REQUEST

Current Zoning: N-1 A (Neighborhood 1-A)
Proposed Zoning: B-2(CD) LWPA (general business, conditional, Lake Wylie Protected Area)

Approximately 1.66 acres located on the south side of Mt Holly-Huntersville Rd between Bellhaven Blvd and Abbington Holly Dr.

The petition proposes to redevelop a site in the Coulwood neighborhood with a carwash including 4,500 square feet of gross floor area and accessory uses permitted in the B-2 district.

PETITION #2022-017

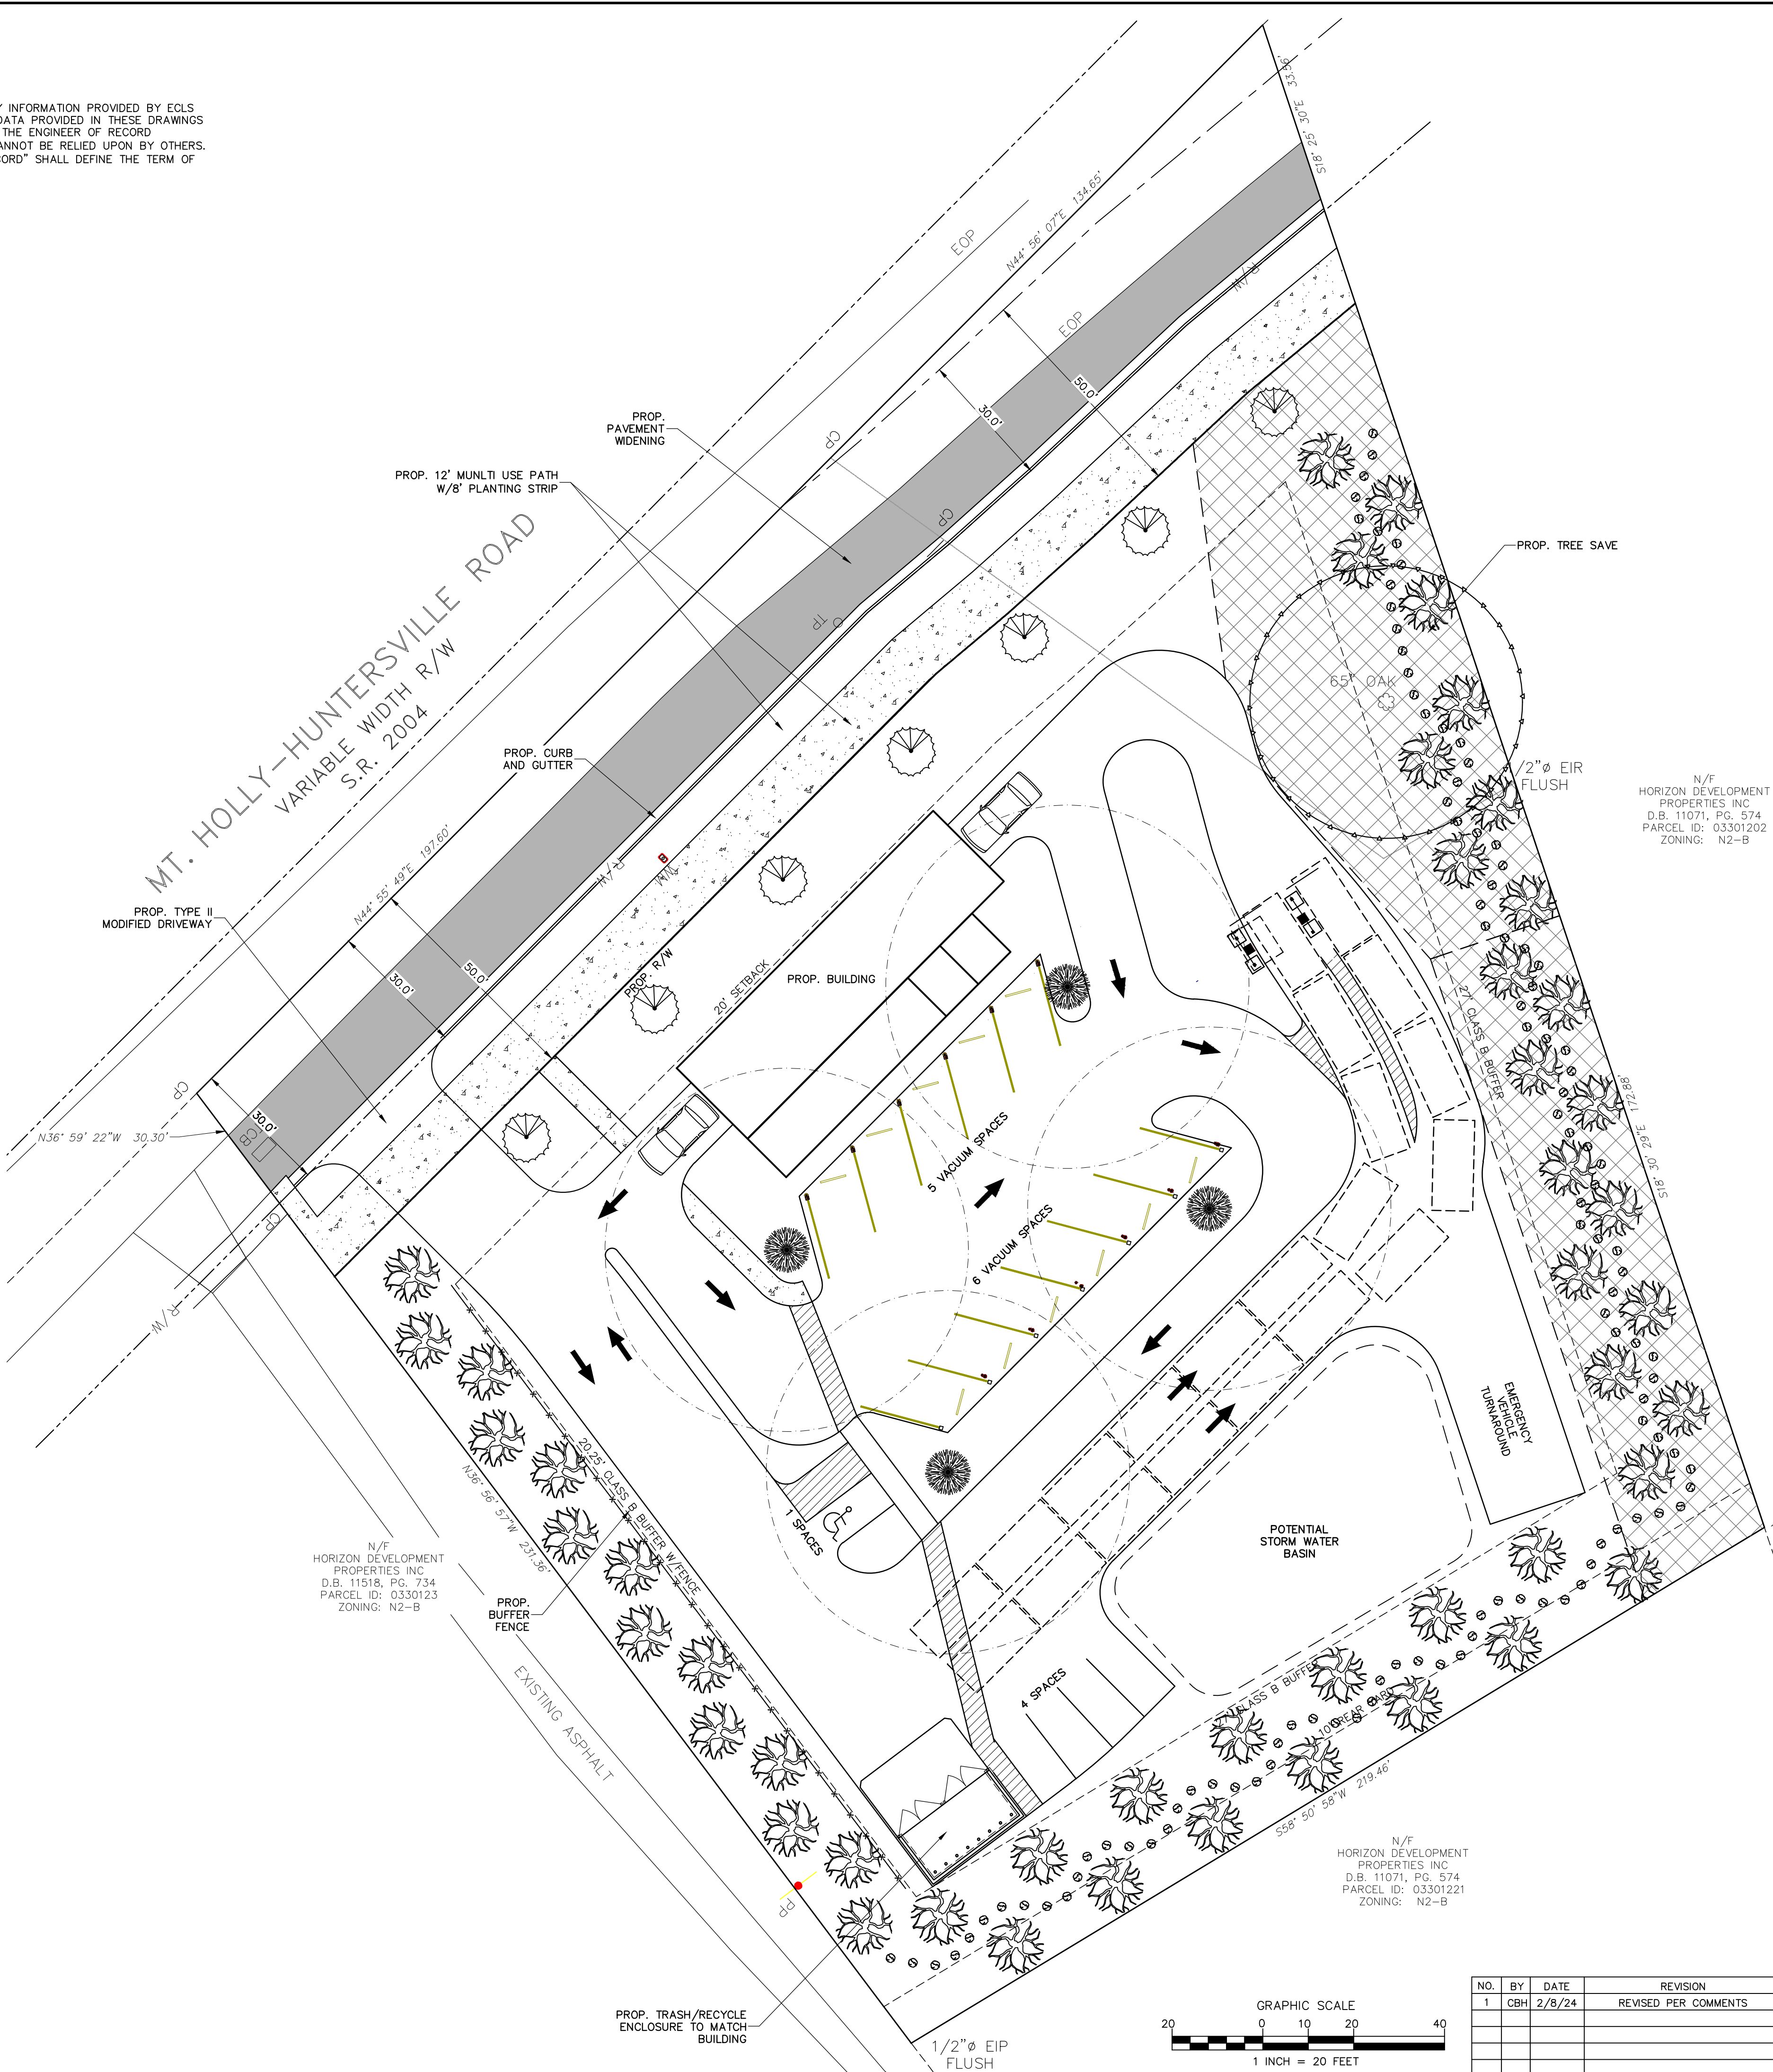
- ~~1. Remove note 5.b. stating that the 6' sidewalk and varied width planting strip along Mount Holly Huntersville will remain. This conflicts with note 5.d. stating that an 8' planting strip and 12' multi-use path will be constructed.~~ **ADDRESSED**

- ~~2. Add conditional note stating that the petitioner will make a concerted effort to preserve the 65" oak tree on site.~~ **ADDRESSED**
